CITY OF ALBUQUERQUE

April 15, 2026

**RE: Geneiva's Arroyo
No Address
Grading and Drainage Plan
Engineer's Stamp Date: 4/1/2026
Hydrology File: L15D064
Case # HYDR-2025-00135**

Based upon the information provided in your submittal 04/09/2026, the Grading and Drainage Plan **is not approved** for Grading Permit and Building Permit. The following comments need to be addressed for approval of the above referenced project.

<b>CITY OF ALBUQUERQUE</b> PARKS & RECREATION DEPARTMENT STRATEGIC PLANNING AND DESIGN	
	<b>GENEVA'S ARROYO</b> <b>GRADING AND DRAINAGE</b> <b>PLAN AND PROFILE</b>	
	DESIGN REVIEW COMMITTEE	CITY ENGINEER APPROVAL
		CITY PROJECT NO. 7404.002
		SHEET NO. C-121

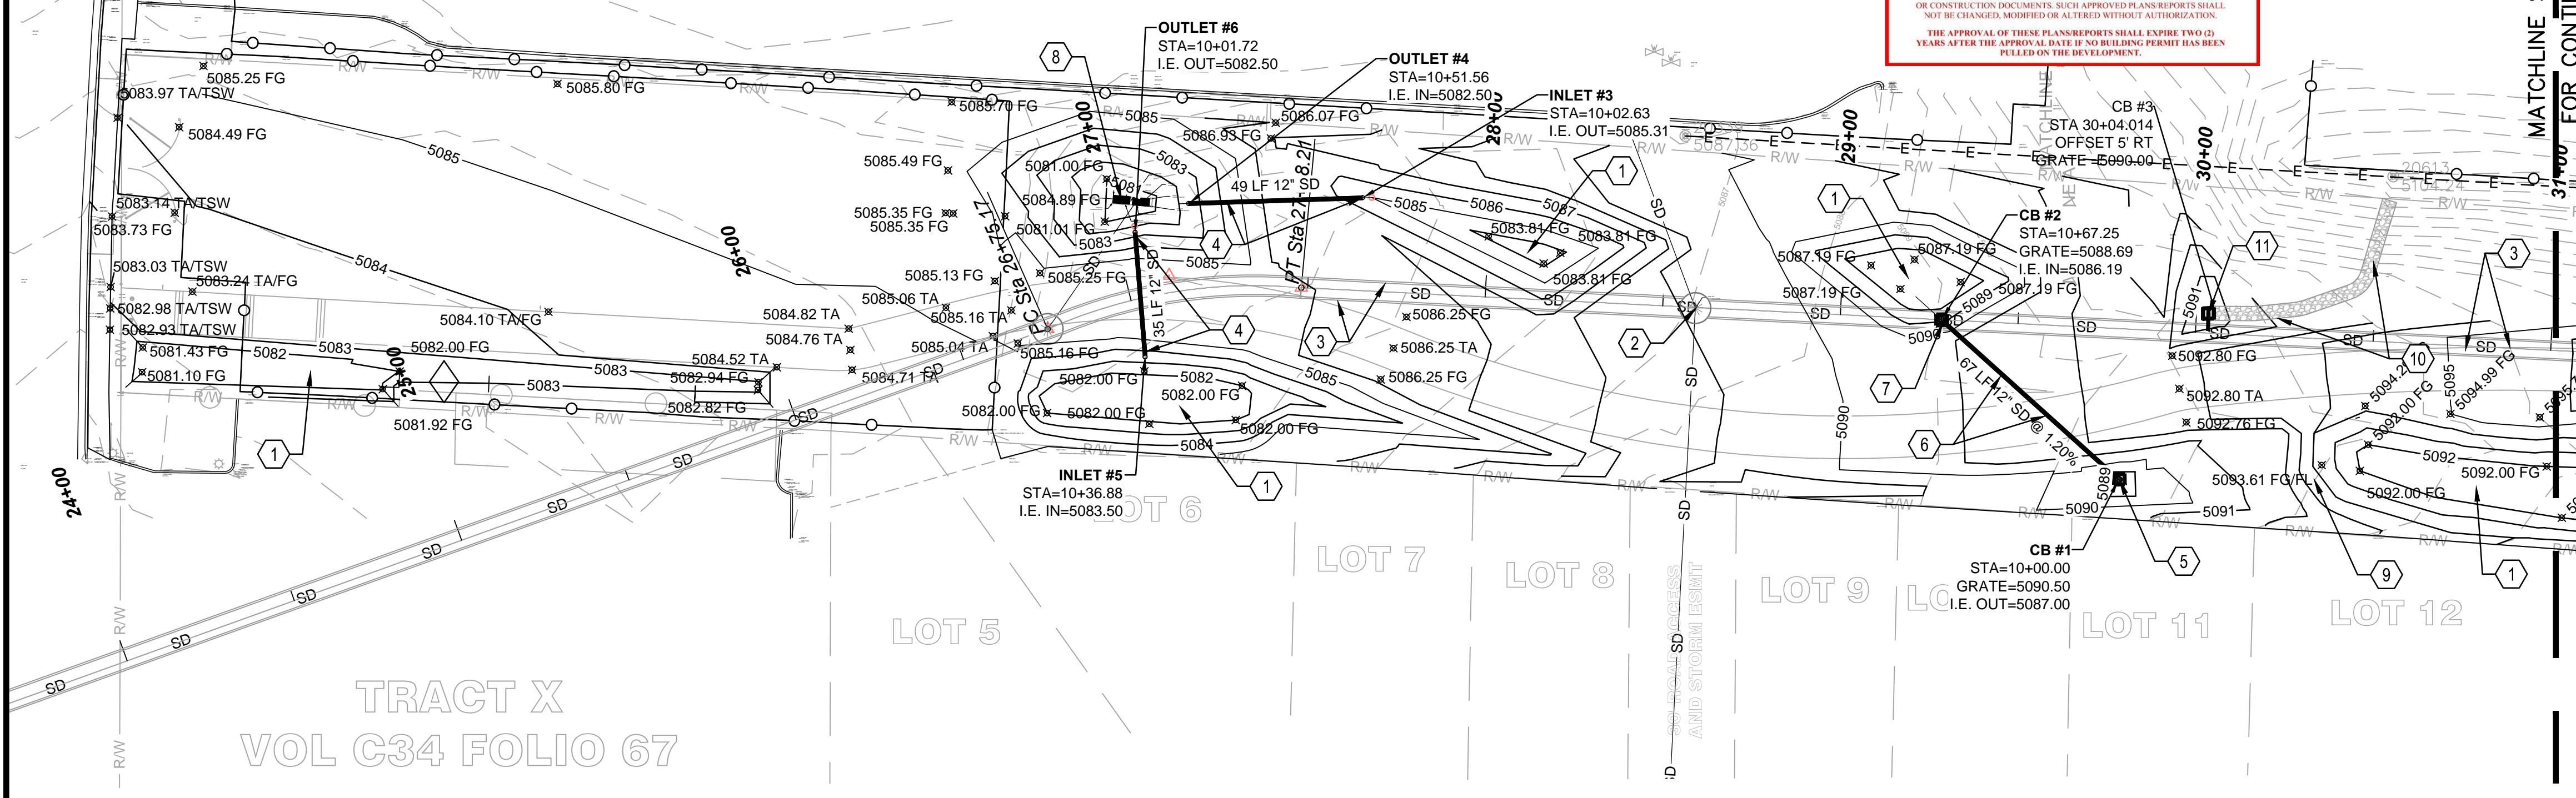
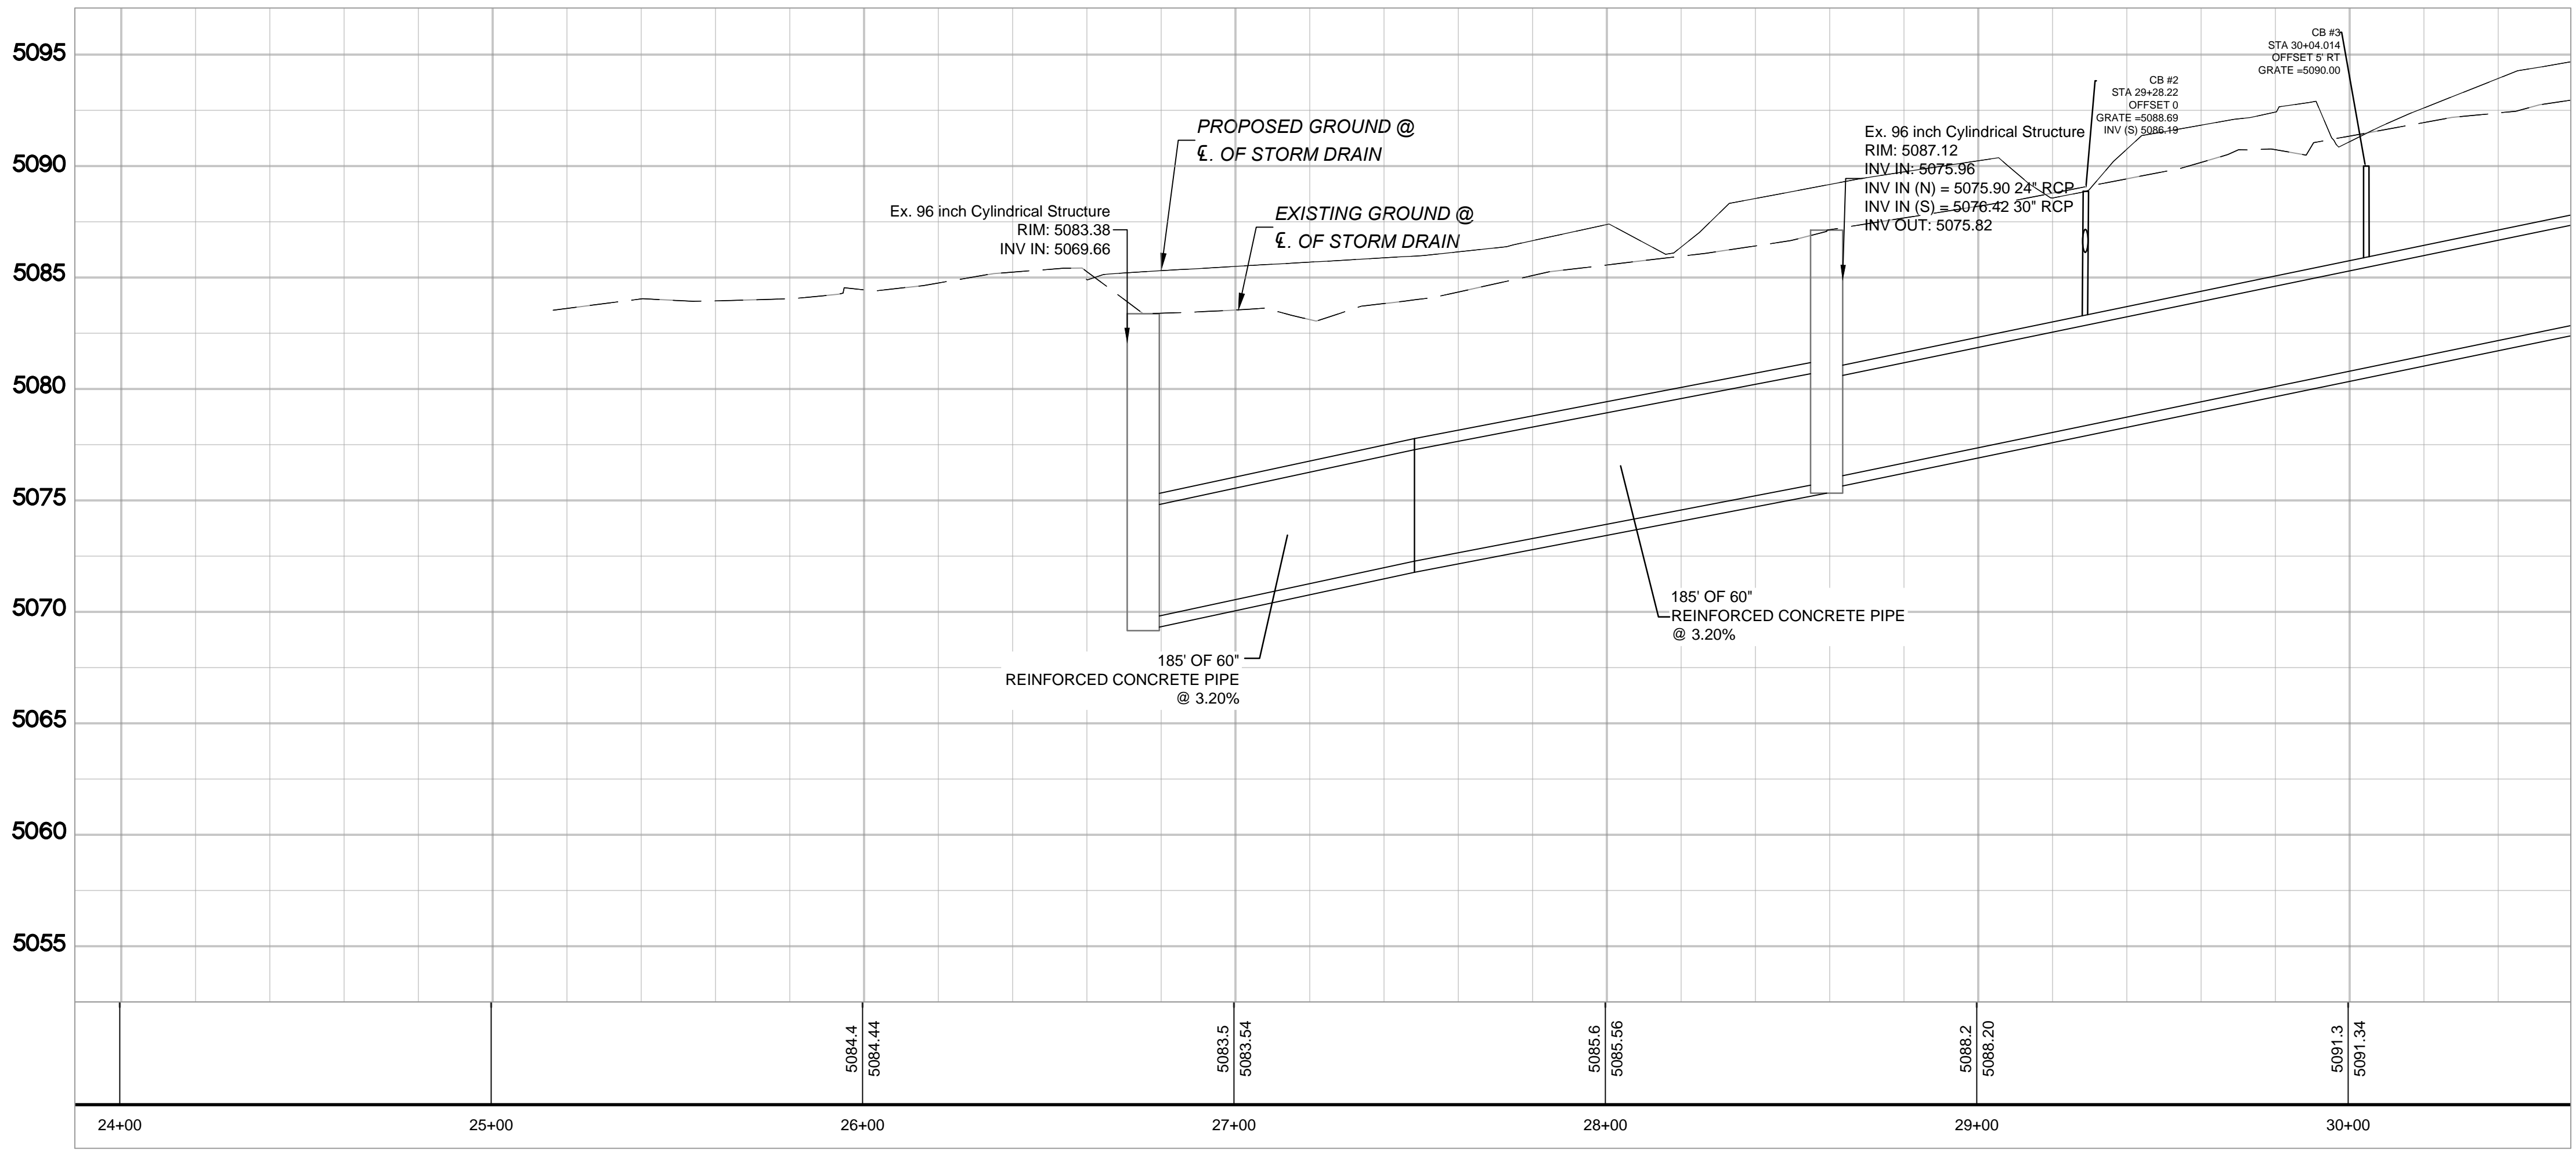
1. A portion of this project is located in a floodplain (A) and a floodplain development permit must be obtained. The permit application must demonstrate zero rise to the base flood elevation, unless a Letter of Map Revision (LOMR) is being prepared. Please contact Tiequan Chen, P.E., CFM for more information regarding floodplain development permits (tchen@cabq.gov or 924-3695).
2. Please provide the Benchmark information (location, description and elevation) for the survey contour information provided.
